Nicola Hopkins
Director of Economic Development and Planning
Ribble Valley Borough Council
Council Offices
Church Walk
CLITHEROE
BB7 2RA

Phone: (01772) 531343
Email: peter.iles@lancashire.gov.uk
Your ref: 3/2022/0317
Our ref: 3_2022_0317-LCC2
Date: 5th June 2025

**Application 3/2022/0317: Reserved Matters application in respect of Phase 5 and 6 to include access, appearance, landscaping, layout and scale with respect to 265 dwellings following outline approval 3/2015/0895.
Land at Higher Standen Farm and Part Littlemoor Farm Clitheroe**

Proposed Bothy Plans and Sections

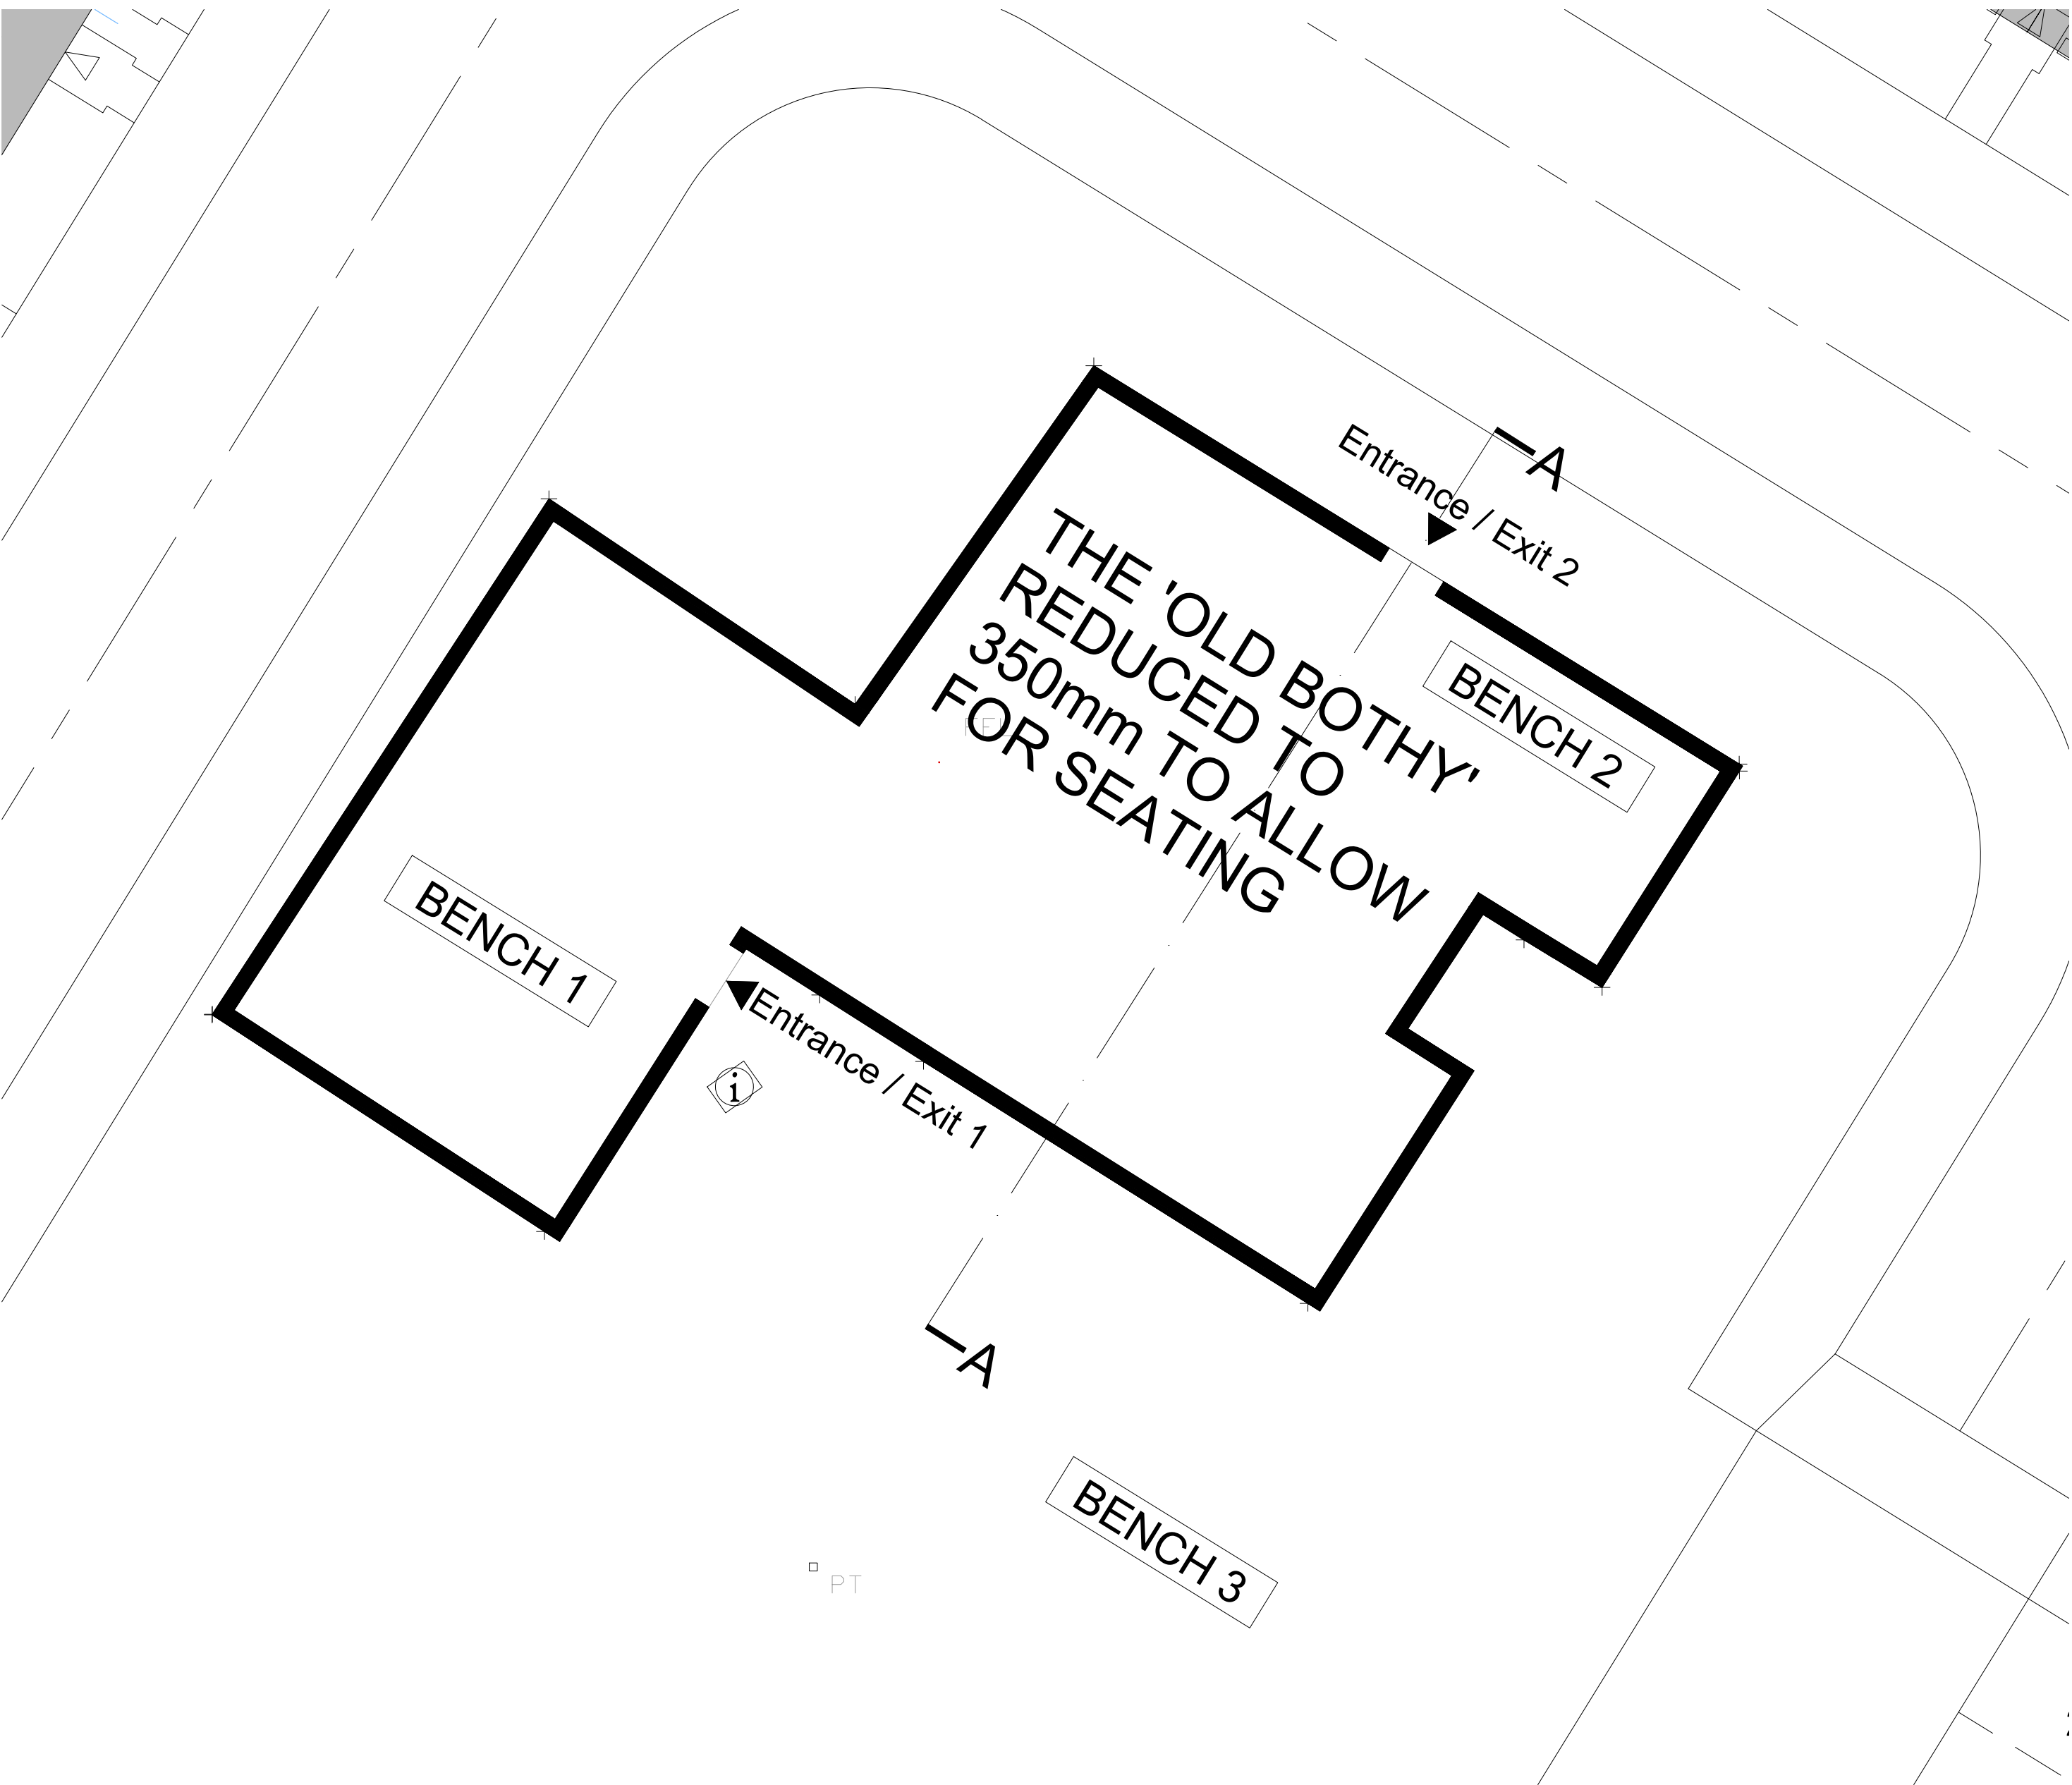
With respect to the field barn referred to as 'The Old Bothy ' in the revised Heritage Statement (HS, April 2025, LanPro Services Ltd, sections 7.1.22-26, 8.3.1-3 and 6-7, and 9.1) we note the proposals to demolish the majority of this structure leaving wall stubs of c.300-400mm tall. The building is dated 1837 (section 7.1.23), but such datestones can mark events other than the erection of the building and it may be earlier in date. Indeed, the HS also notes an association with the nearby Listed Gd II 15 Little Moor (7.1.26) suggested to be of 18th-19th century origin. It has clearly been subject to alterations and adaptations in the past, reflecting changes to agricultural practices since its construction.

There a brief description of the building and some photography within the HS, and the building is noted there as being of local heritage significance (7.1.30). There follows an attempt to suggest that the proposed demolition of the majority of the structure provides a long-term future for the remaining stub walls and, with the ability to better appreciate the (former) setting of the monument, the impact on the heritage significance of the site is 'less than substantial' (section 8.3.7). Mitigation of the impact of the demolition is suggested to be the retention of the stubs of walling, the provision of nearby benches and the installation of a historic information plaque. No historic building recording or archaeological investigation around the site is now suggested.

As noted in our earlier letter there is an opportunity to retain the building in situ and convert it to other uses, such as a dwelling (or even a community space). This would retain the majority of the fabric of the building, maintain its presence in the landscape and preserve the energy expended in the original extraction of materials and construction. It would also avoid the carbon footprint of the demolition and disposal of the resulting waste. It is acknowledged that the building is in poor condition, but, as noted in the structural survey (Shape Consulting Engineers, 2000, Section 4), a great deal of blame for this can be laid on recent poorly-designed works to the roof, blocking of openings and use of the incorrect materials.

If the Council are convinced by the need to remove the majority of the building, we would again recommend that a formal building record is made, prior to any demolition being started. This can also be required by a planning condition.

Condition: No works to the building known as 'Old Bothy', including any clearance/demolition or preparation works shall take place until the applicant, or their agent or successors in title, has secured the implementation of a programme of archaeological building recording to level 3 as set out in "*Understanding Historic Buildings*" (Historic England 2016). This must be carried out by an appropriately qualified and experienced professional contractor to the standards set out by the Chartered Institute for Archaeologists and in accordance with a written scheme of investigation, which shall first have been submitted to and agreed in writing by the Local Planning Authority. These works shall result in the compilation and deposition of a formal report on the works undertaken and the results obtained. The development shall be carried out in accordance with the agreed details. A digital copy of the report shall be placed in the Lancashire Historic Environment Record.
